M3 Junction 9 Improvement

Scheme Number: TR010055

7.12.1 Statement of Common Ground with Winchester City Council (Rev 1)

7.12.1 STATEMENT OF COMMON GROUND WITH WINCHESTER CITY COUNCIL

DRAWING TITLE  
FIGURE 2.5 - THE SCHEME: TEMPORARY TRAFFIC DIVERSION ROUTES  
APFP REGULATIONS 5(2)(a)  
SHEET 5 OF 12  
DOCUMENT REFERENCE 6.2

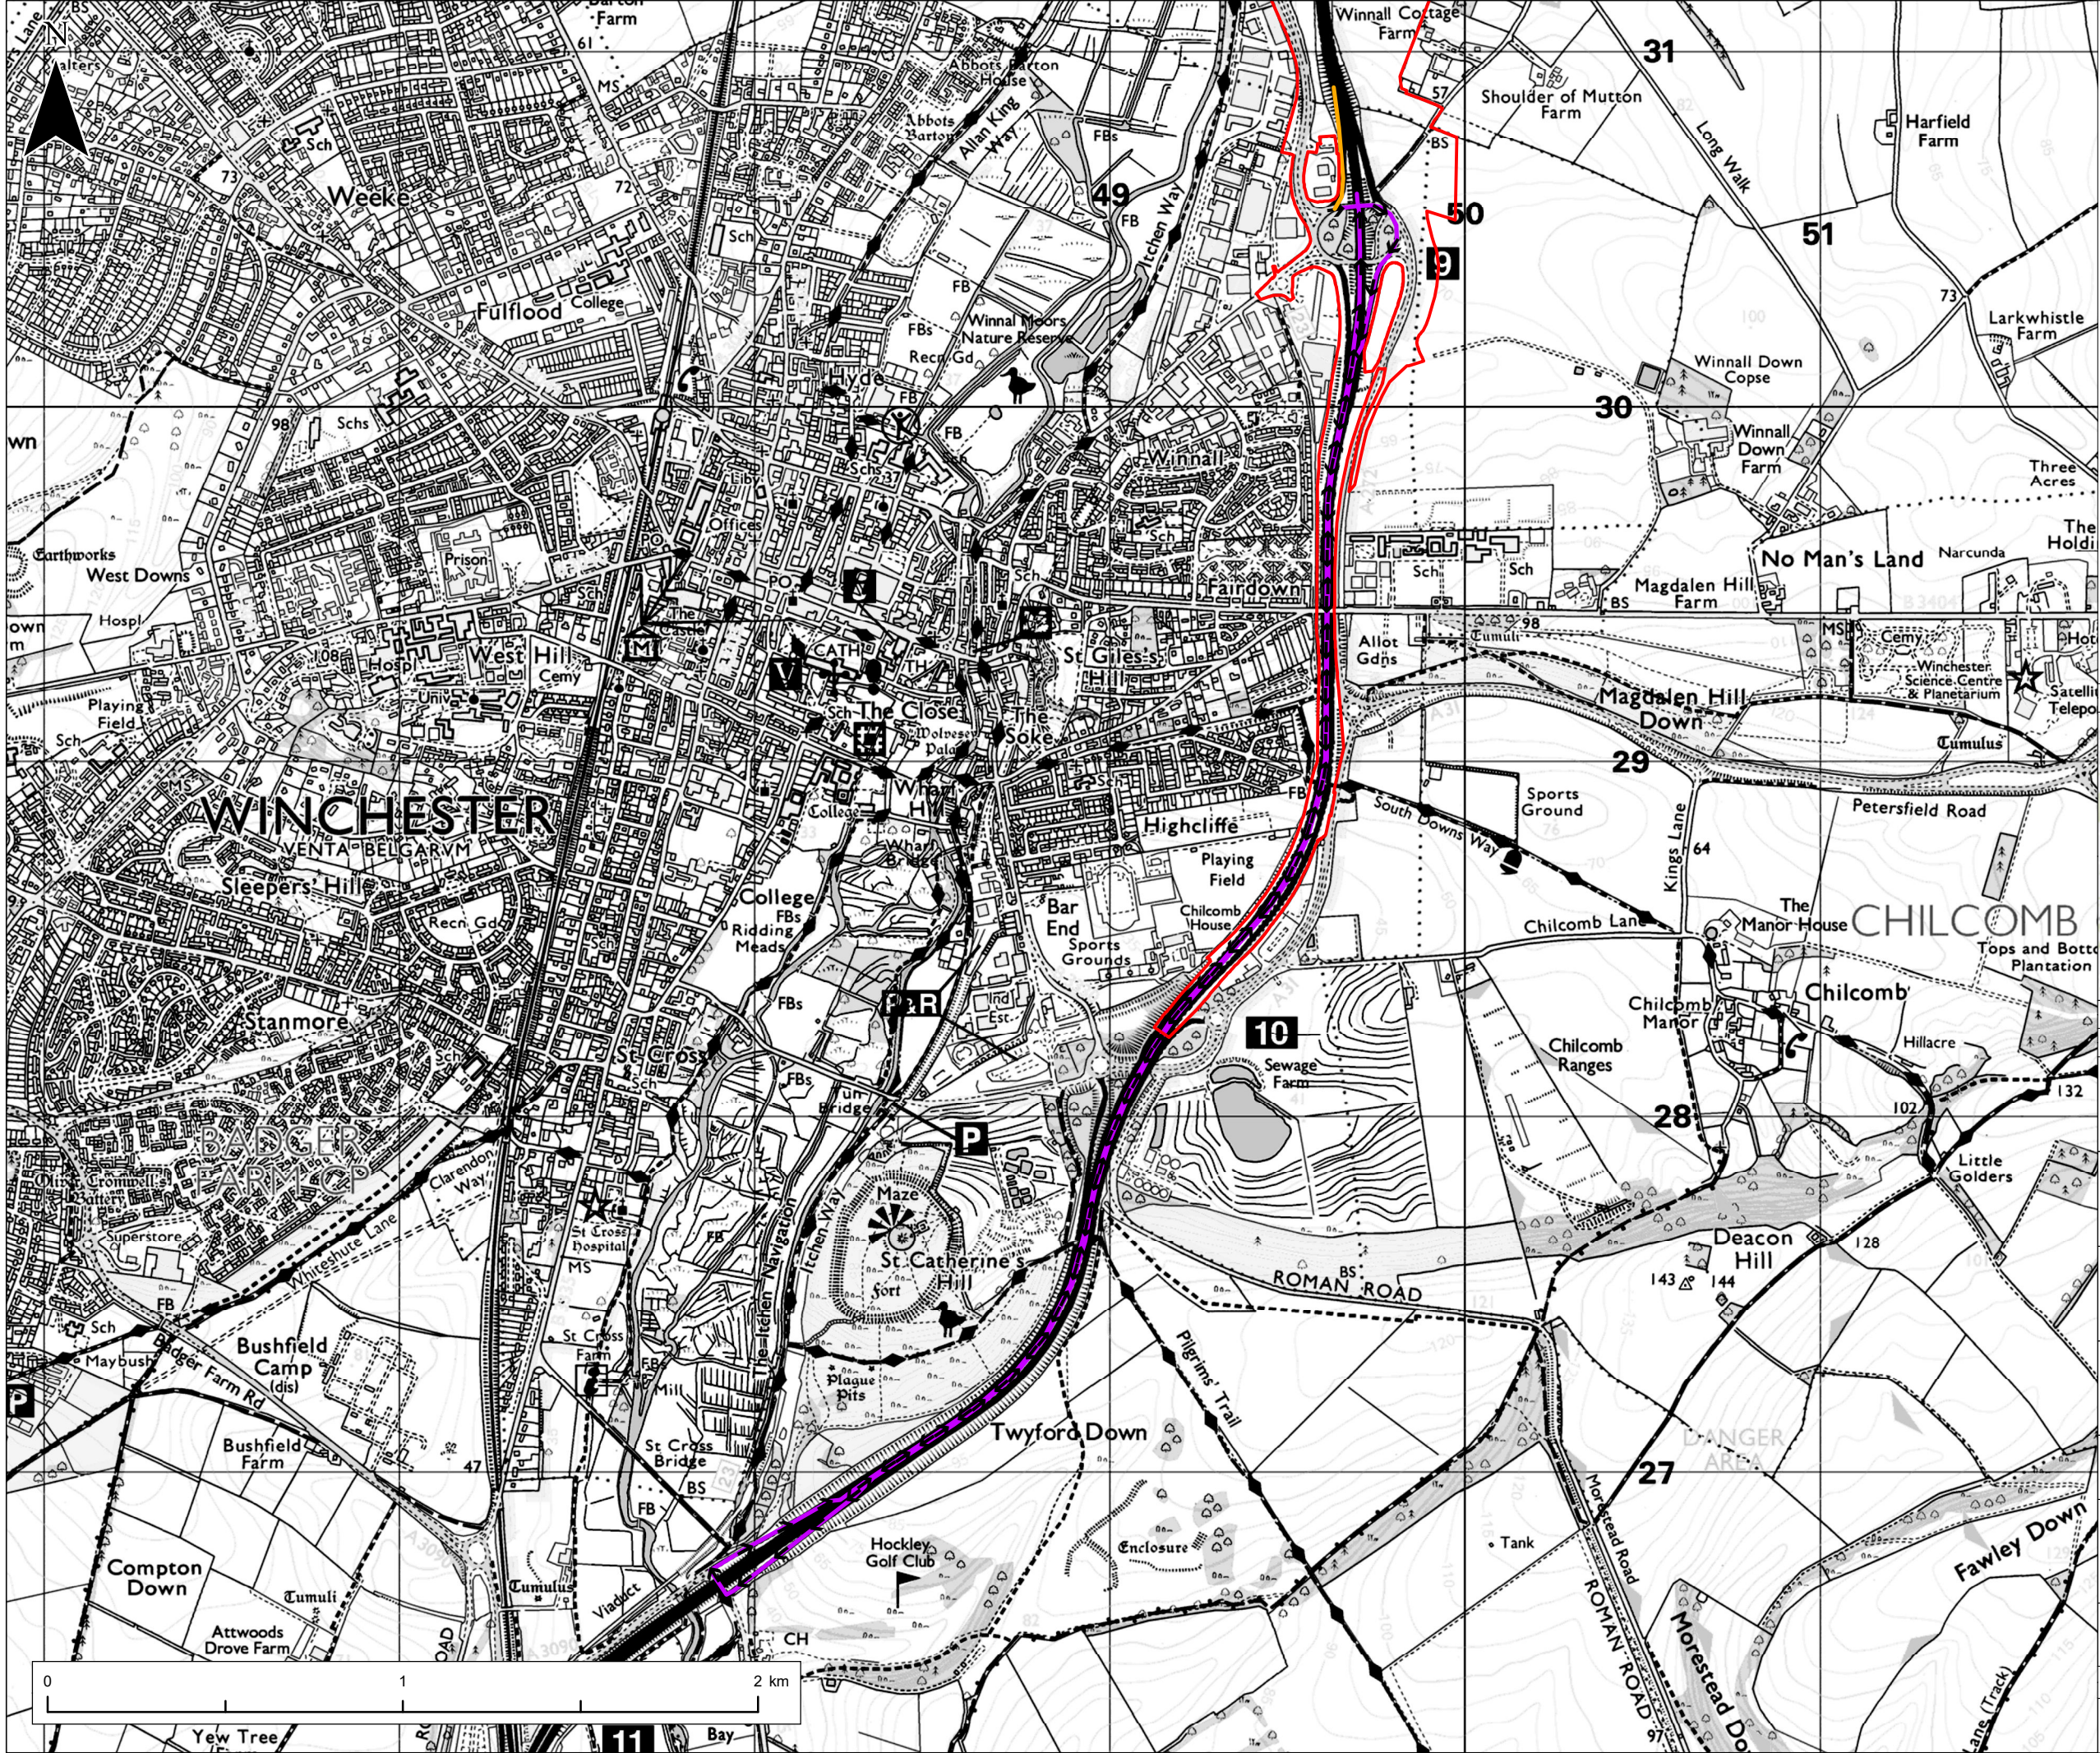
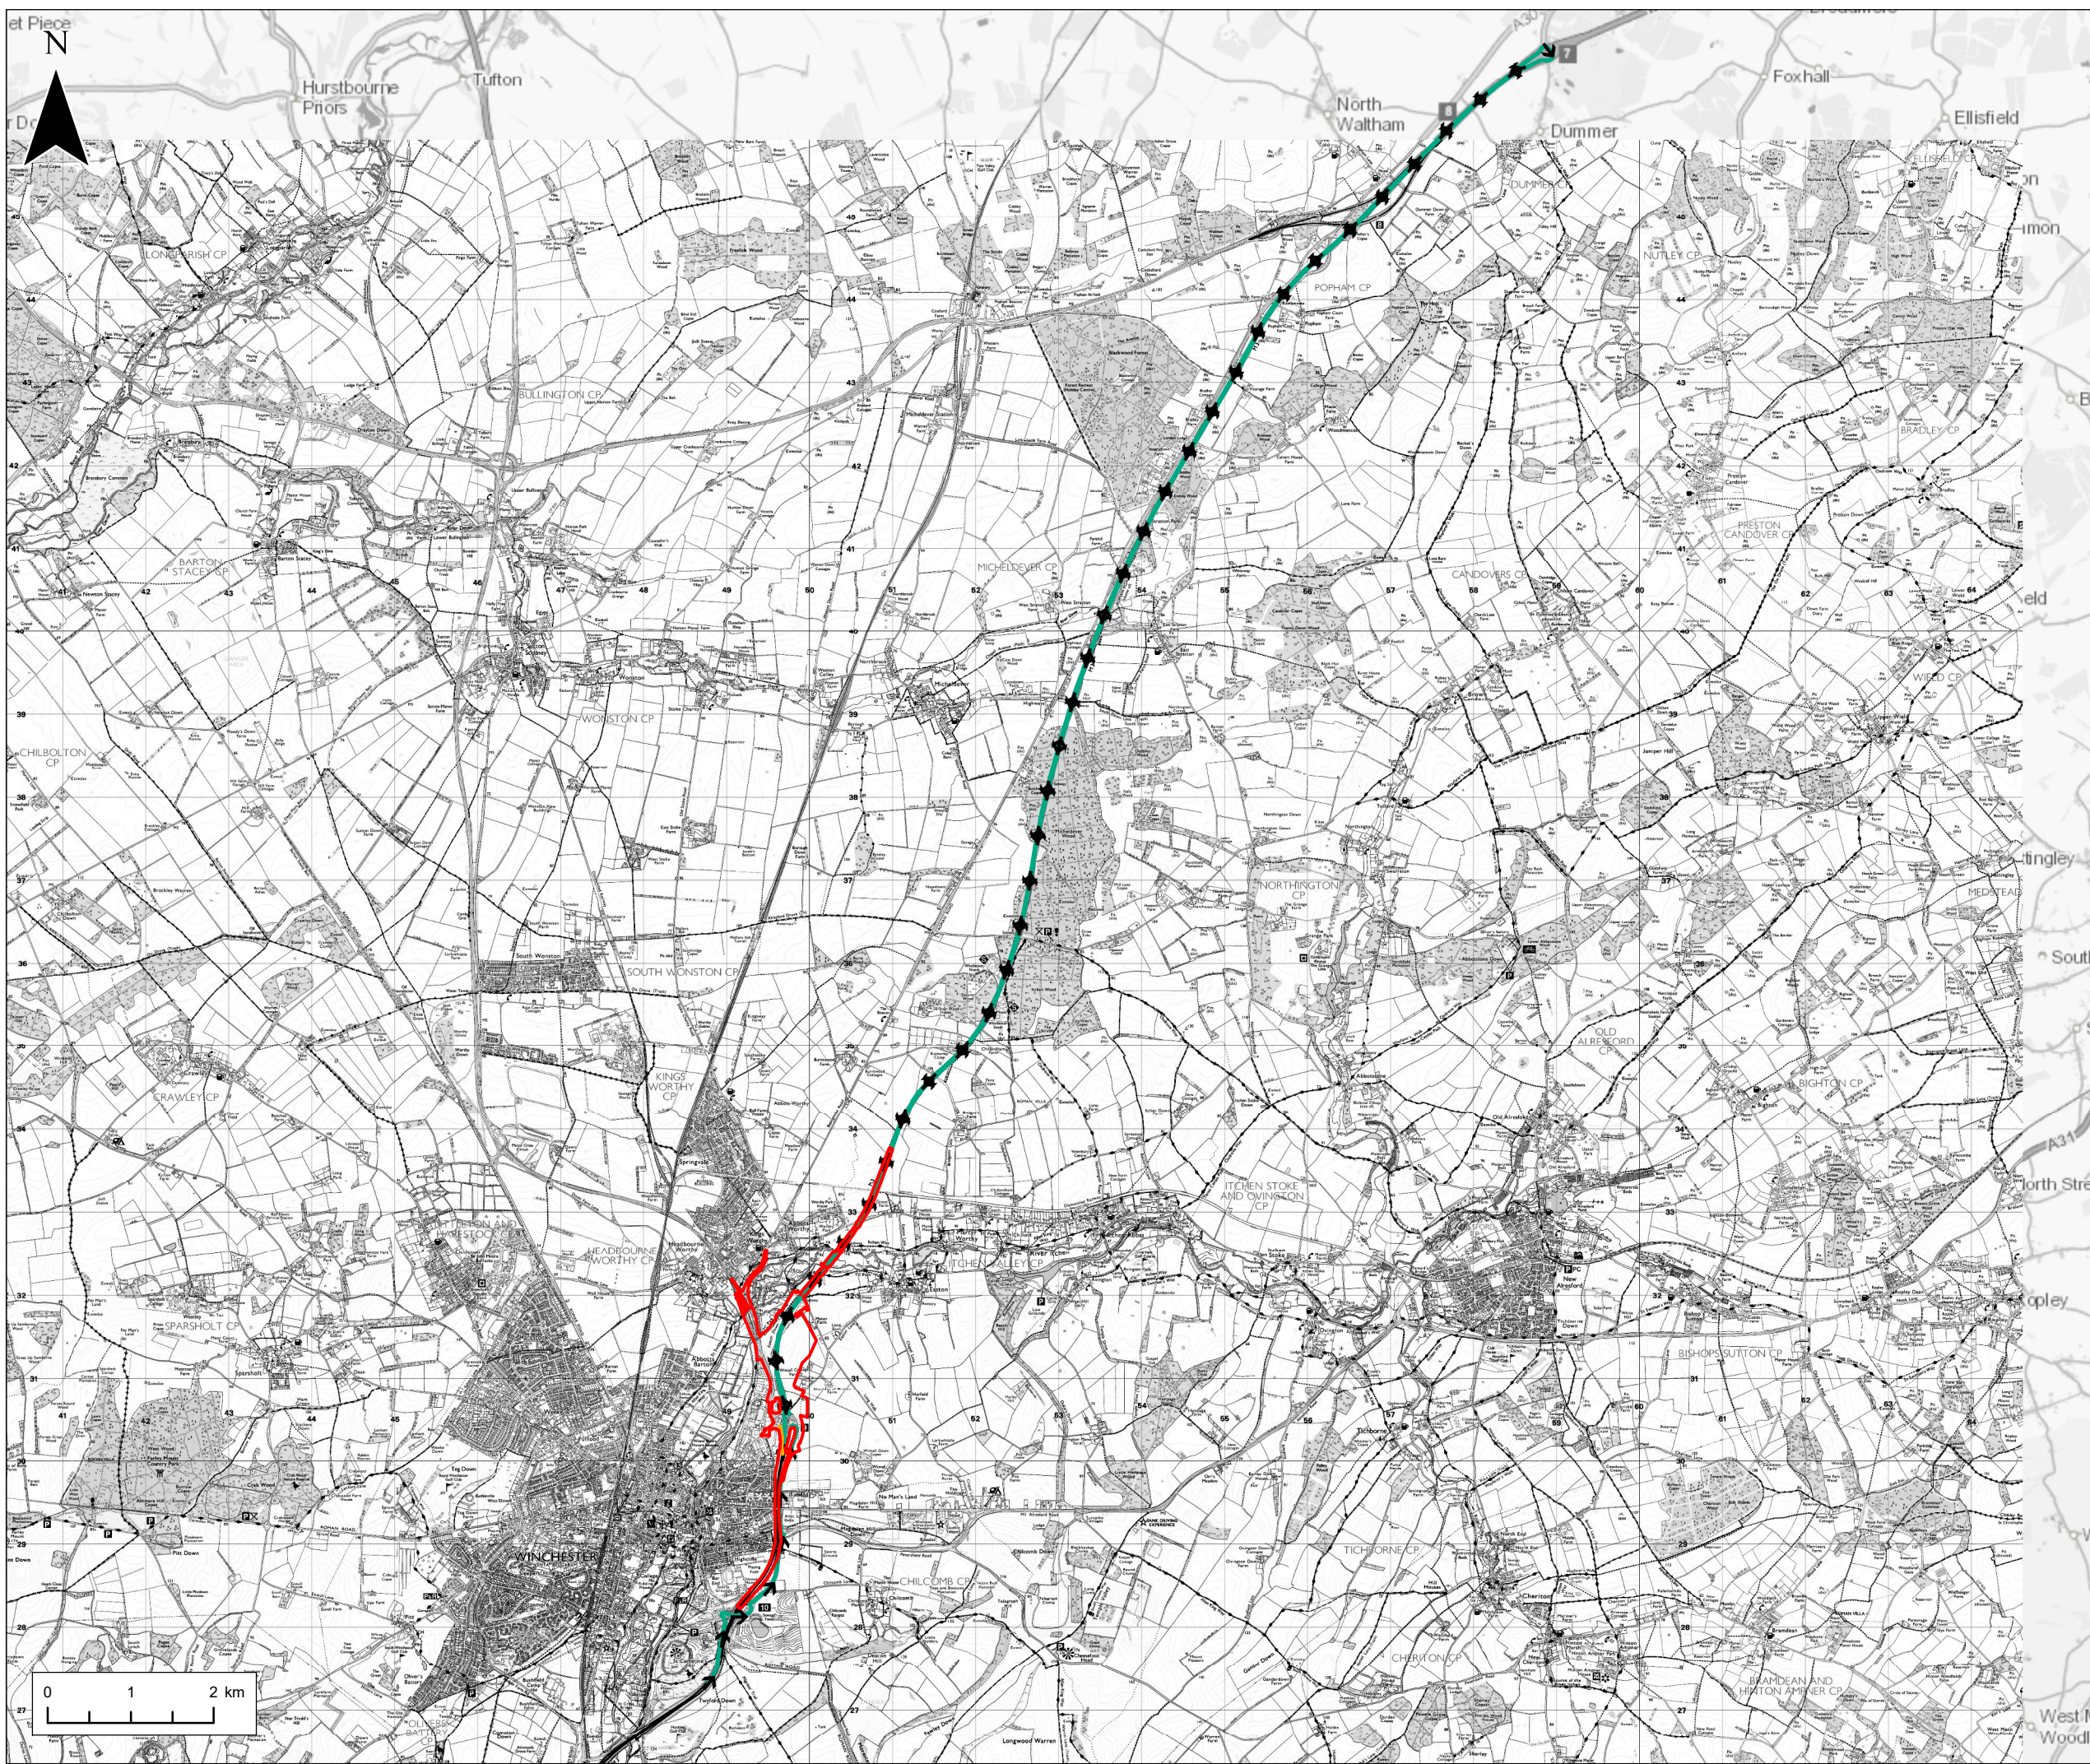
3.6	Mitigation Section 5.8 of Chapter 5 (Air Quality) of the ES (6.1, Rev 1) outlines the essential mitigation during construction.	Chapter 5 (Air Quality) of the ES (6.1, Rev 1)	Although this has been covered in Environmental Statement - the air quality and noise impacts assume indicative diversion routes are used that in reality do not seem to realistic to likely resultant patterns at such times. At ISH2 it was confirmed that discussions will be held between the Highway Authority and Applicant concerning advanced positioning of signs and general methods to ensure compliance with	National Highways is reviewing Winchester City Council's recent comment on this matter.	Under Discussion	18 August 2023
